Your Ref: OWPC15858
Our Ref: FP/193/17/HH 28-07-2017
Please ask for:
Mark Jones

Town & Country Planning Act 1990 (as amended)
Town & country Planning (Development Management Procedure) (England) Order 2015

Proposed extensions
5 Roundle Avenue Felpham

Proposed North Elevation

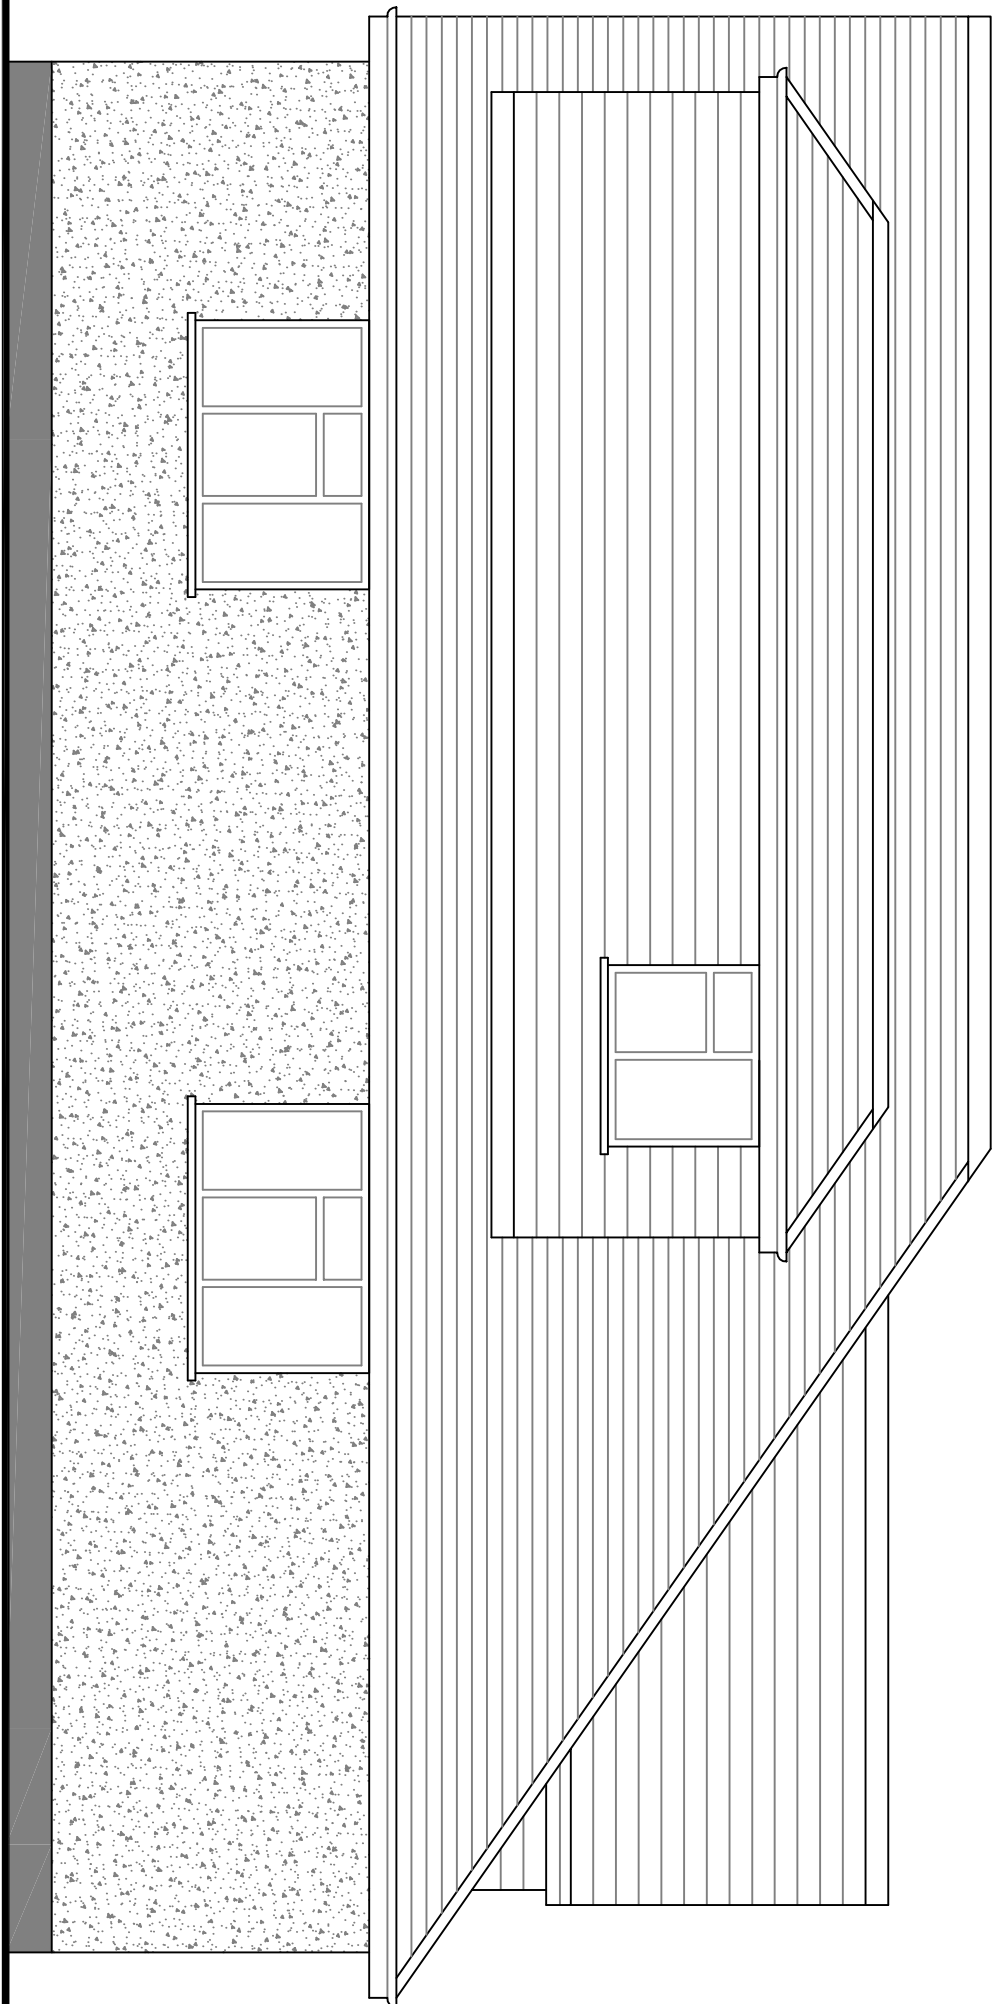
- The upper storey, as shown in the plans, is totally out of proportion with the rest of the property;*
- The proposed extension will be visually dominant compared to the nearby properties, adversely affecting the street-scene;*
- Other properties on the estate have been extended in ways that are sympathetic with neighbouring properties, for instance by using Velux windows rather than the large dormers. proposed. We suggest that this approach is adopted for this property.*
